Comments on NG's responses on PEA Appendix I – Heritage [REDACTED] Farm [REP3-137]

Image A14.3.1 Operational Noise Baseline Information

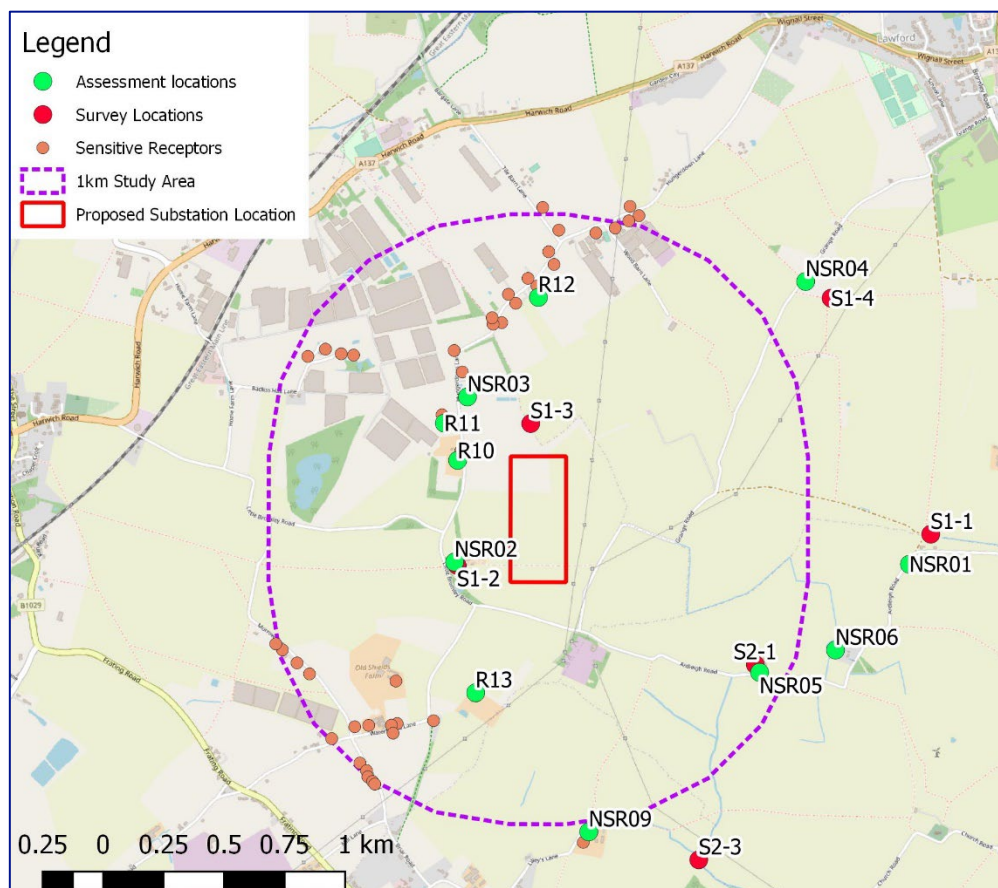
NG states that "adverse effects from operational noise are not expected at [REDACTED] Farm." However, in its Volume 6 Environmental Statement, 14.7 Operational Noise Assessment, 14.7.5, NG refers to the Heritage Asset [REDACTED] Farm as "the worst affected receptor R.10 [REDACTED] Farm." It goes on to state that "the context is a relatively low specific noise level in a rural area, above existing average levels of ambient noise during night-time periods (36dB LAeq, 16h)" and "the specific noise level marginally exceeds the SOAEL during daytime and night-time periods. Outcome – likely significant effect." Once again, deliberate downplaying and failure to represent the truth by NG about its disastrous impact on a Grade 2 Heritage Asset.
